Application for removal or variation of a condition following grant of
planning permission. Town and Country Planning Act 1990.
Planning (Listed Buildings and Conservation Areas) Act 1990

Proposed conversion and extension to existing garage into ancillary accommodation, new driveway to front of property. This application affects the character & appearance of the Angmering Conservation Area.

A/54/20/HH

Condition 2- The development hereby approved shall be carried out in accordance with the following approved plan:
- Proposed Site/Block Plan and Proposed Garage Conversion Plan and Elevations - WL_101 - L- 200a - April '20

HAPA ARCHITECTS			
Ariston, Water Lane, Angmering, Littlehampton			
Status	PLANNING	Drawing Title	PROPOSED SITE PLAN/ BLOCK AND PROPOSED GARAGE CONVERSION PLAN AND ELEVATIONS
Date	APRIL '20	Scale	1:50, 100 & 500 @ A1
Drawing Number			L-200b

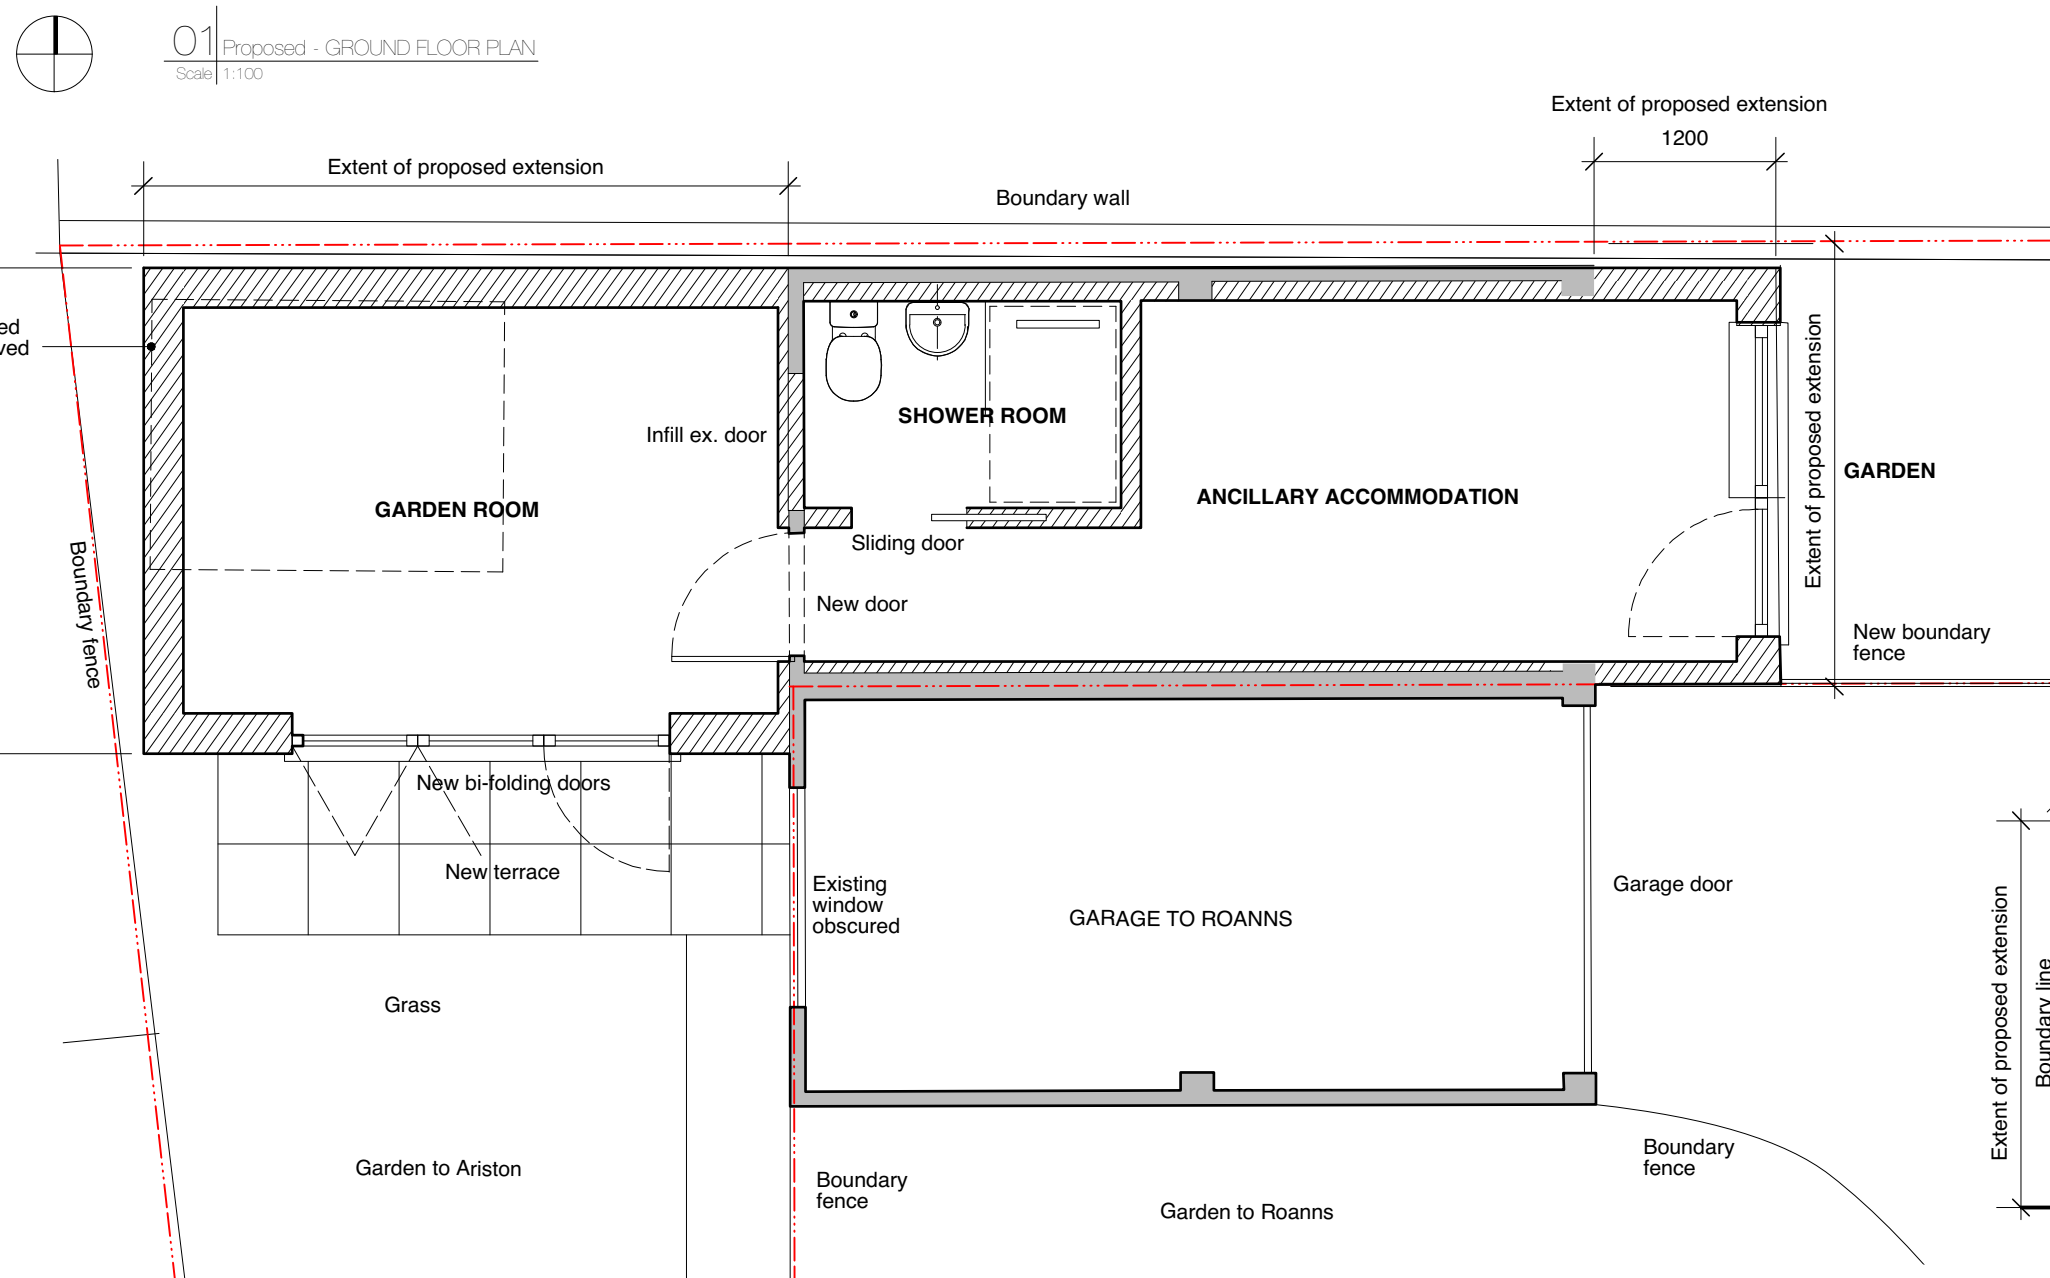
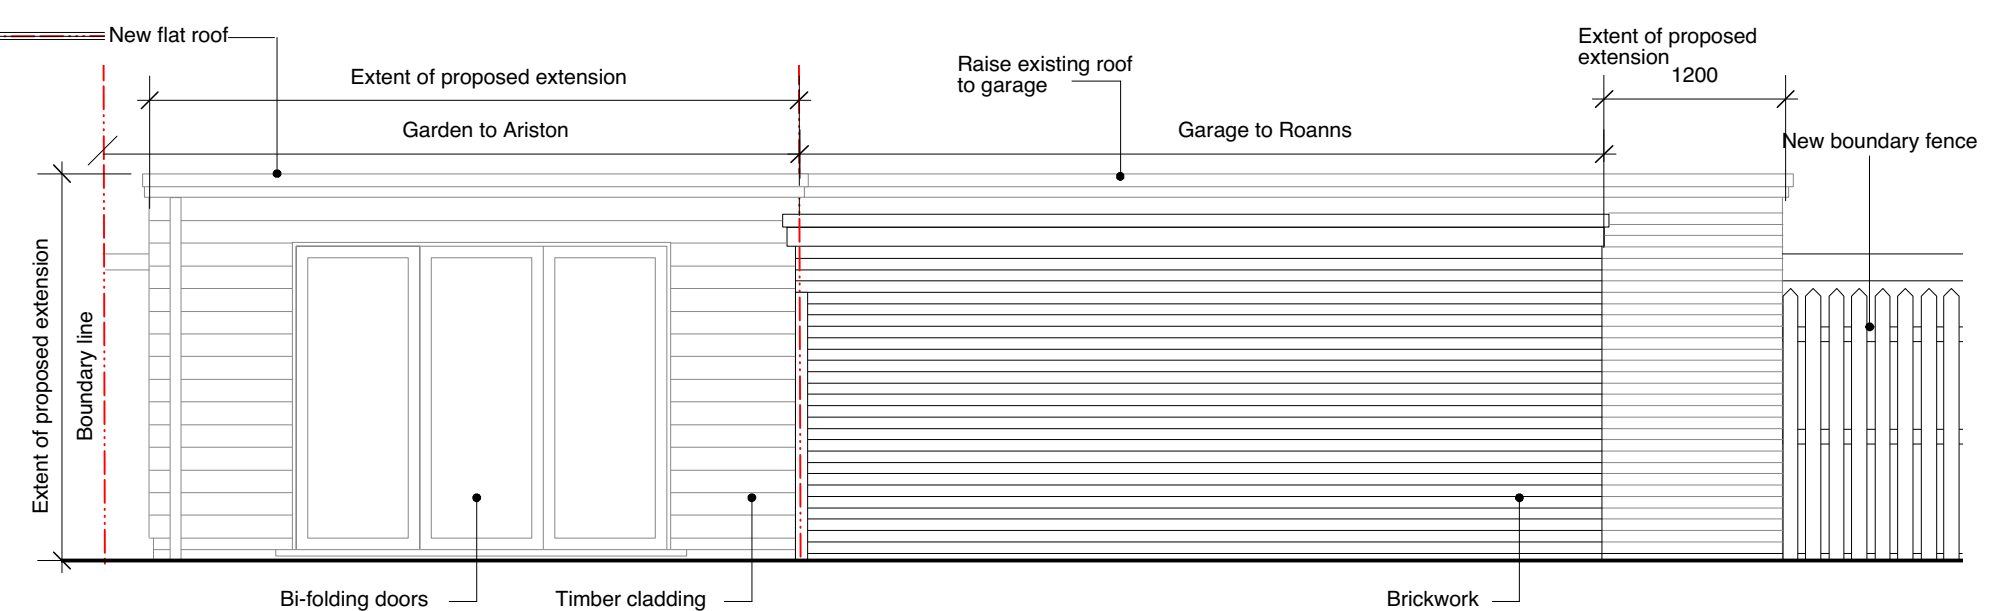
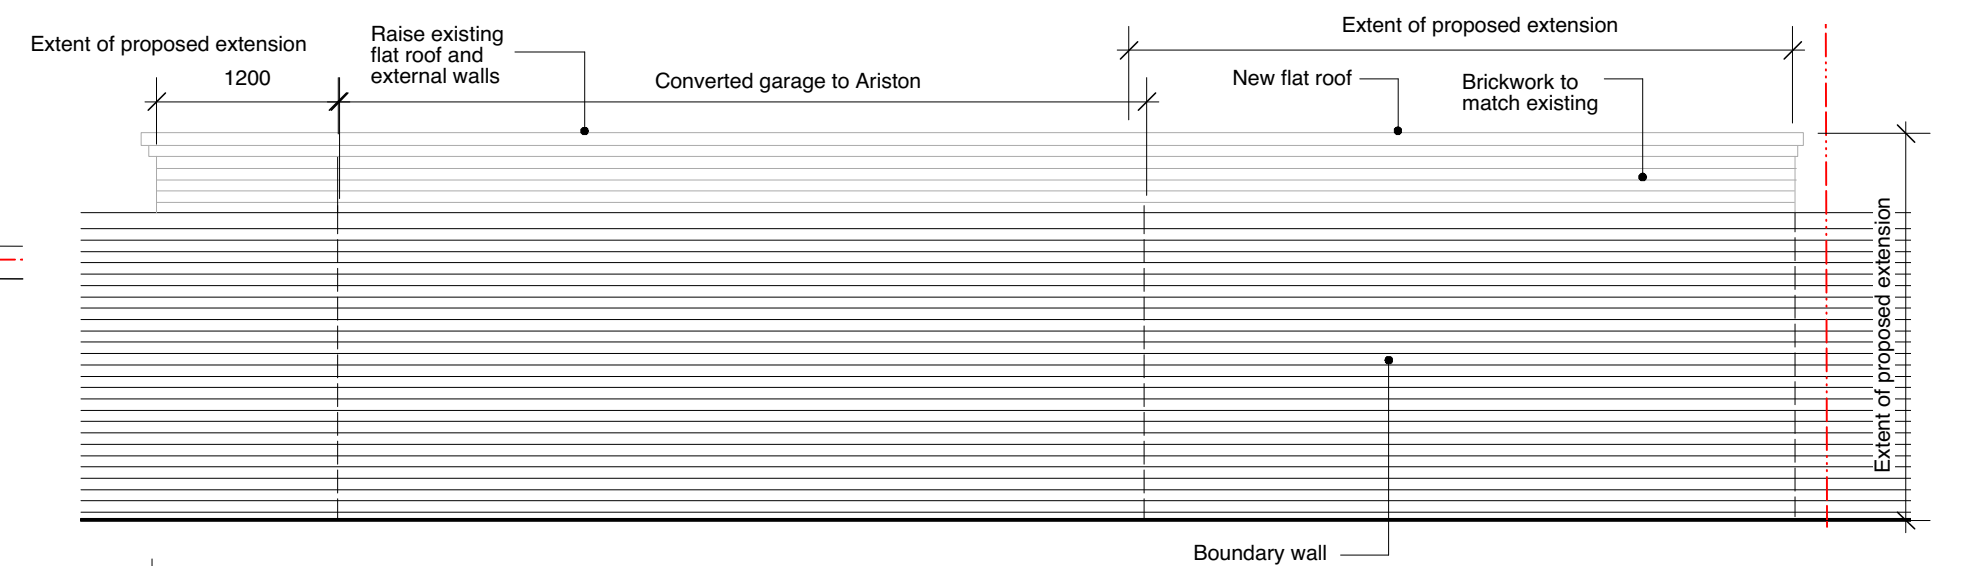
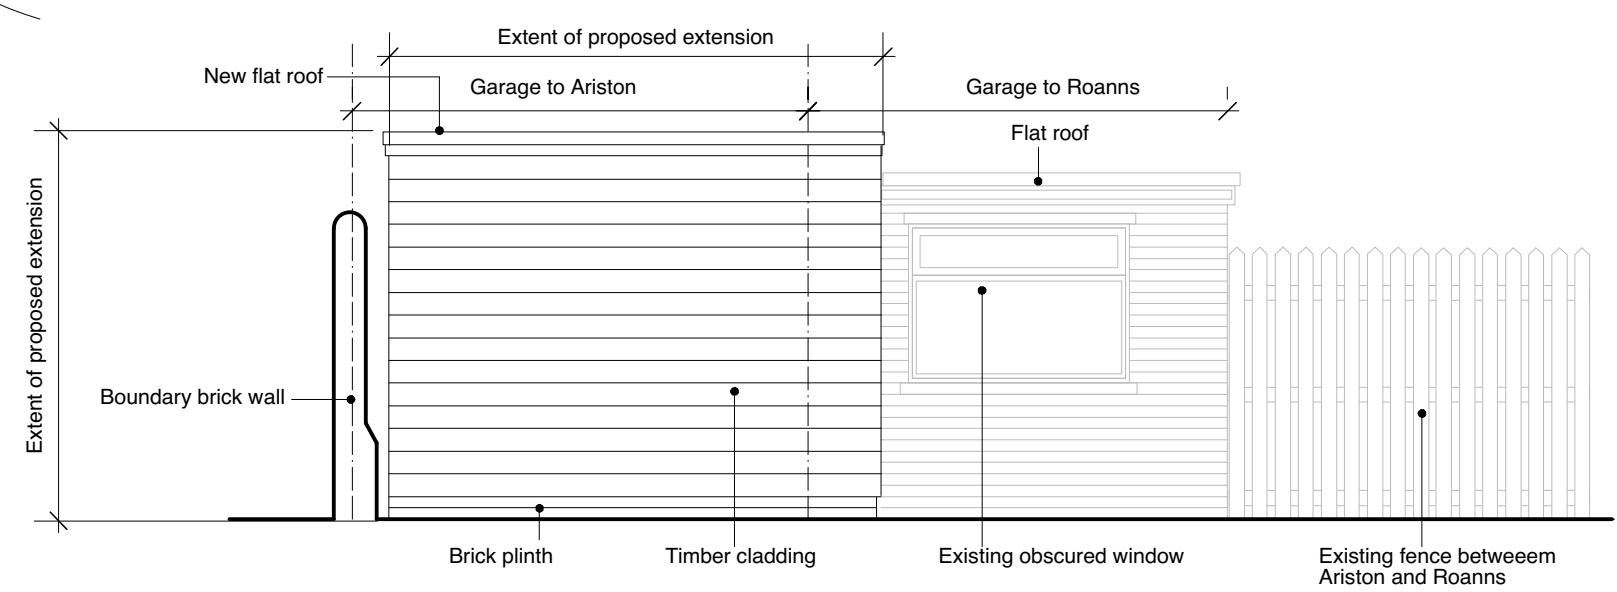
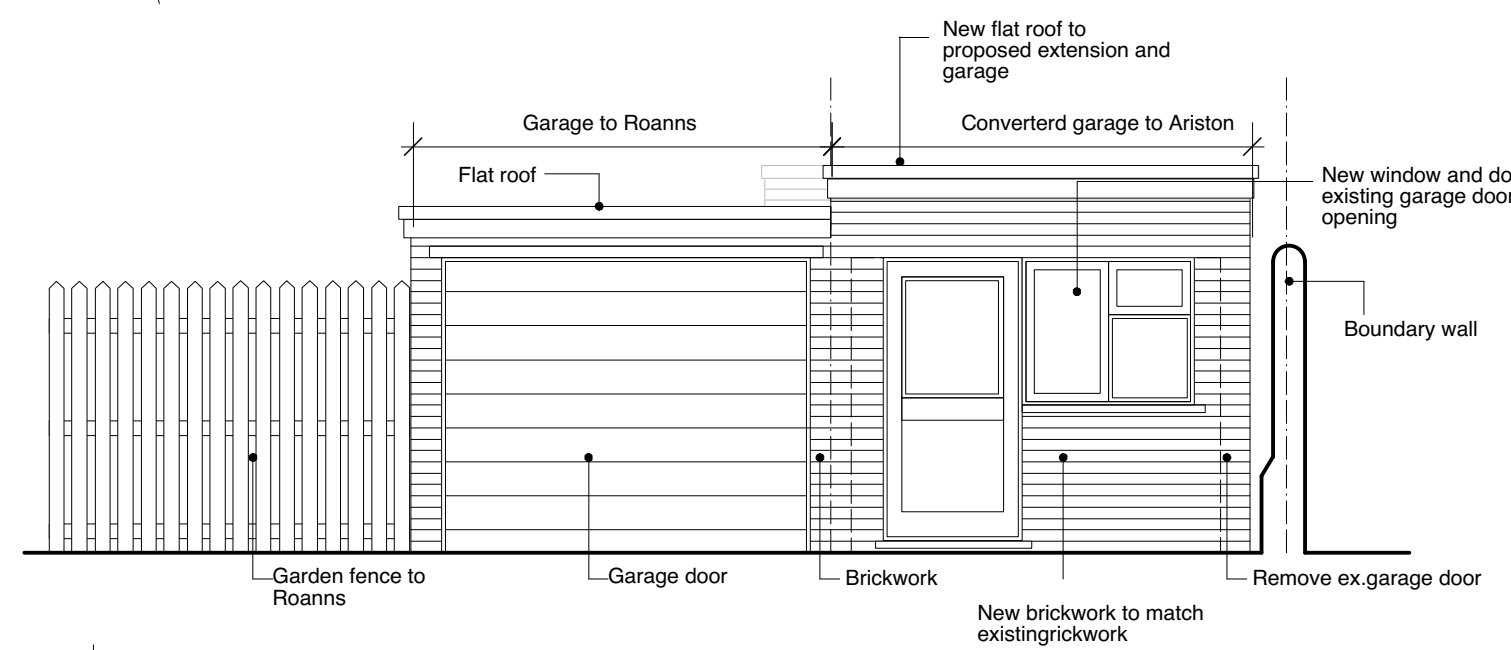
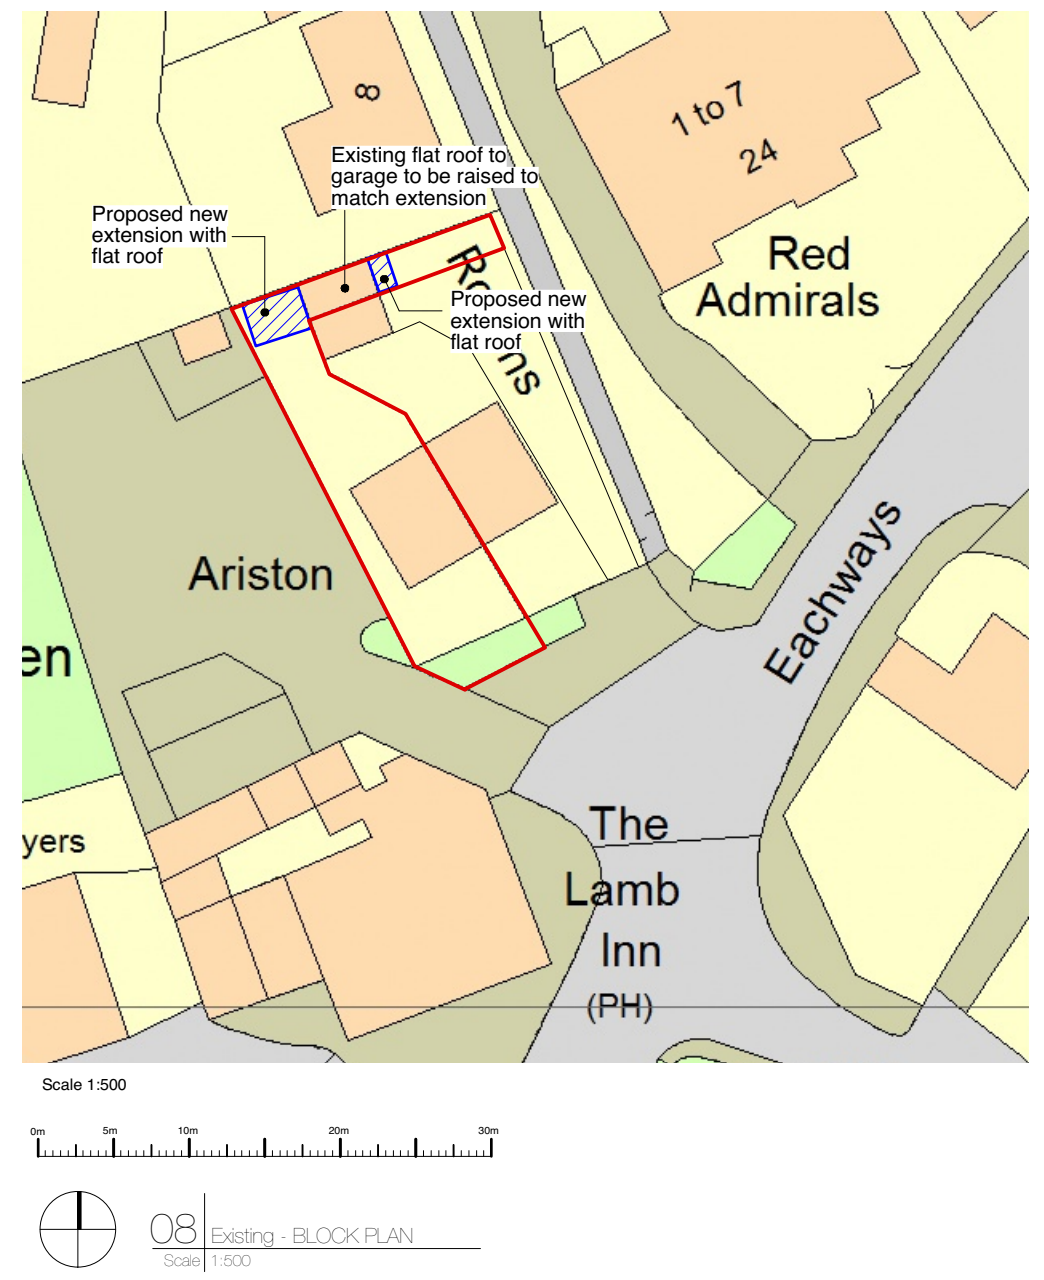
We are proposing an additional 1.2m extension to the existing garage

We would like to substitute approved drawing AL-200a for AL-200b
